CITY OF ALBUQUERQUE

October 17, 2017

**Re: Valle de Atrisco
Erosion and Sediment Control Plan
Engineer's Stamp Date 9-28-17 (P09E002D)**

VALLE DE ATRISCO
EROSION & SEDIMENT CONTROL PLAN

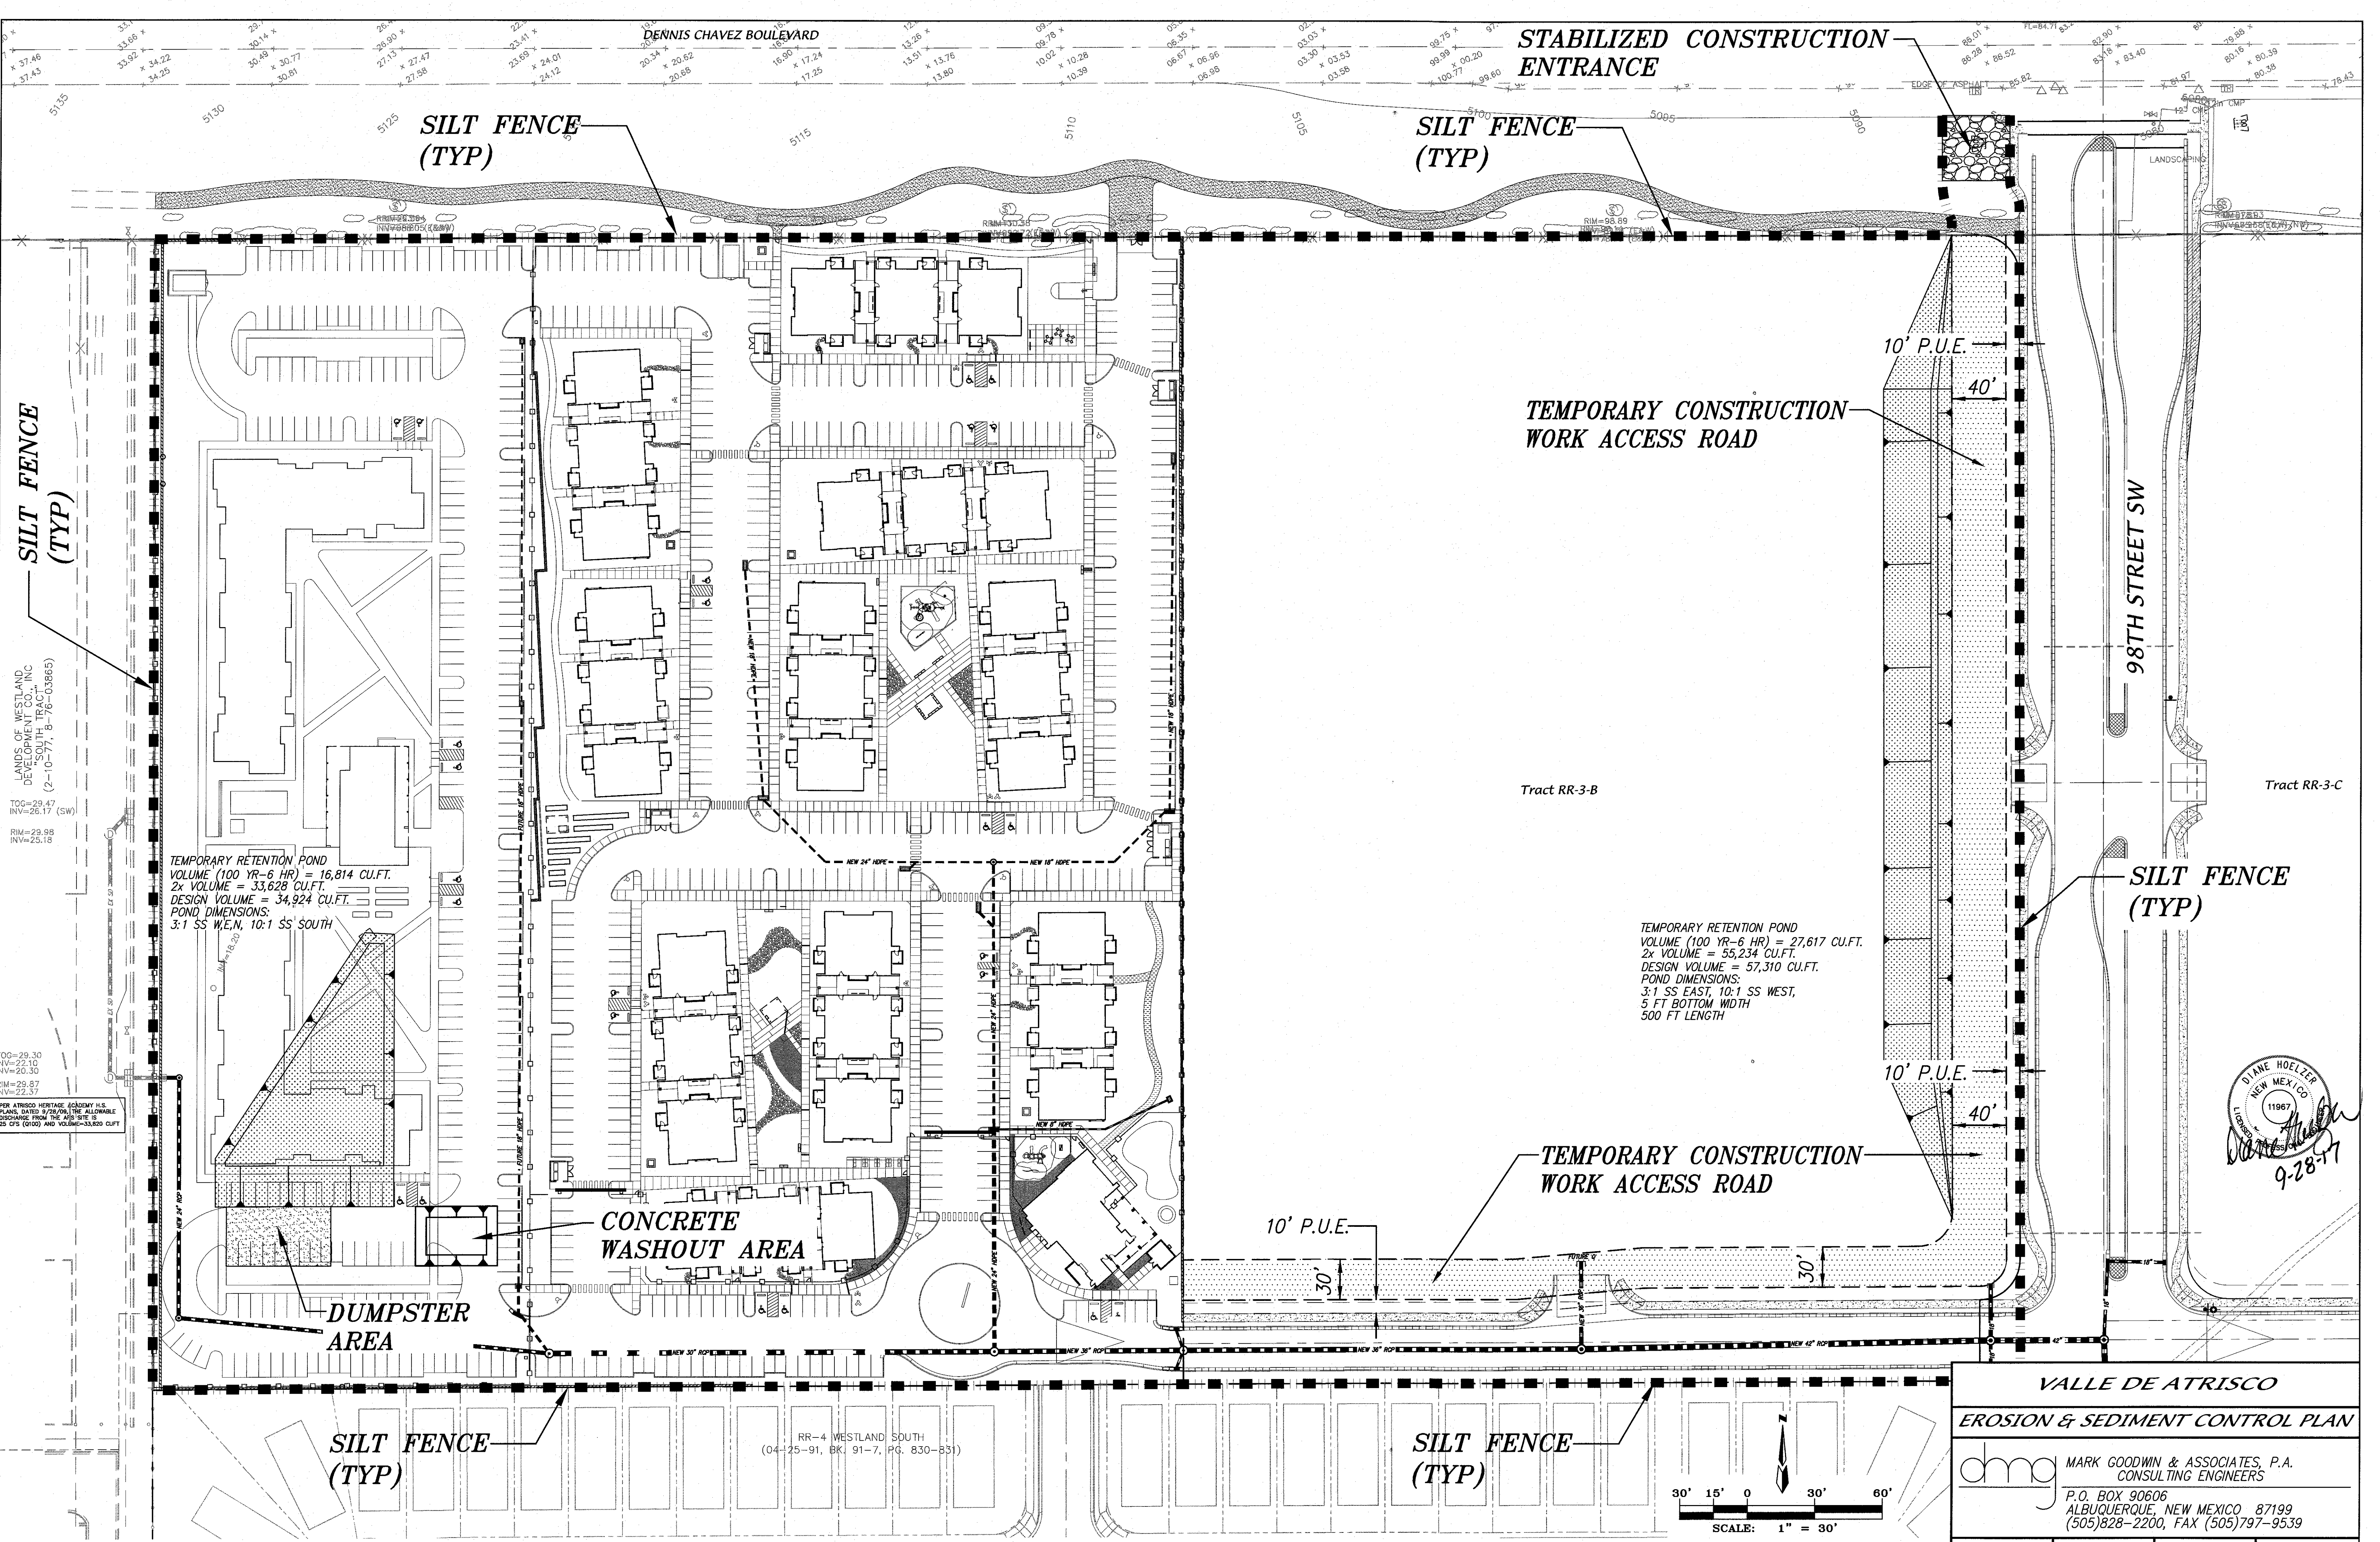
1. The plan does not show the project limits. The grading plan shows a ditch and a pond south and east of the project in Bernalillo County.

2. The disturbance in Bernalillo County is to be approved by Bernalillo County.

Provide the City with an approval letter from Bernalillo County.

3. Provide grades. Additional comments may arise once grades are provided.

4. From aerial imagery, it appears the offsite flows will miss the proposed pond. How does the drainage enter the proposed pond east of the project?

5. Provide inlet protection for proposed inlets.

6. BMPs have not been proposed for the trail on Dennis Chavez and for construction of 98th St. Will there be a separate plan for Work Order approval?
